An
Bord
Pleanála

Board Direction
ABP-302829-18

The Board decided, as set out in the following Order, that the installation of new replacement uPVC windows to the front façade of building at 27 O'Connell Street, Limerick, is development and is not exempted development.

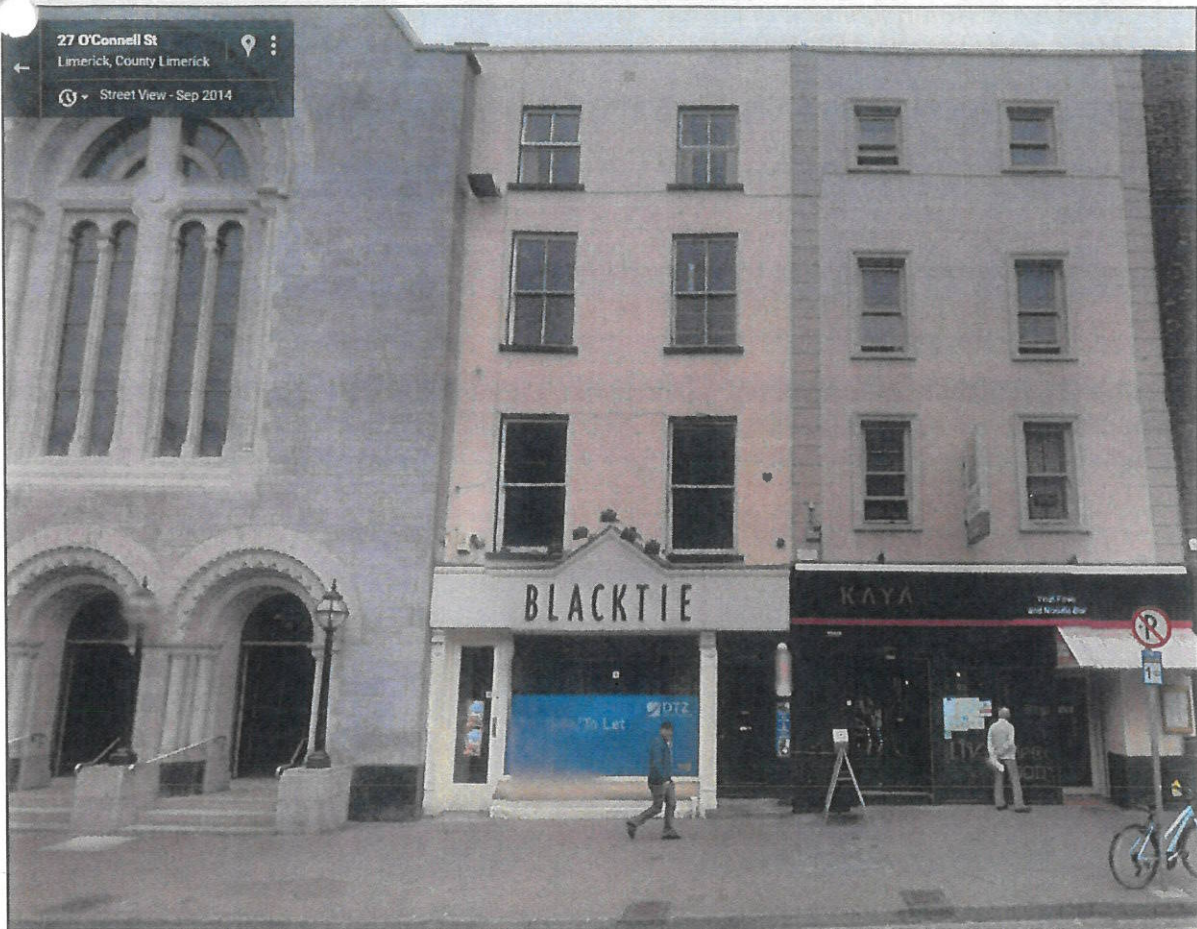
- (b) The replacement of the six sash windows that had previously been on the front elevation of the subject property with uPVC framed windows involves the carrying out of works for the alteration of this structure. However, the works materially affect the external appearance of the structure so as to render that appearance inconsistent with the character of the structure, having regard to the glazing pattern, the thickness of the frames and the openings of the replacement windows, and having regard to the fact that the original fenestration design and materials used contributed to the character of the structure;

- (c) The replacement of the six sash windows that had previously been on the front elevation of the subject property with uPVC framed windows materially affects the external appearance of the structure so as to render that appearance inconsistent with the character of the neighbouring structures, and in particular the adjoining property to the south, which has retained its original openings and sash windows, and the Augustinian Church to the north, which is a Protected Structure;

- (d) The subject development therefore does not come within the scope of the exemption afforded under Section 4 (1)(h) of the Planning and Development Act 2000, as amended, and there are no other exemptions provided for in the Act, or in Regulations made pursuant to the Act, whereby such development would be classified as exempted development. The subject development is, therefore, not exempted development.
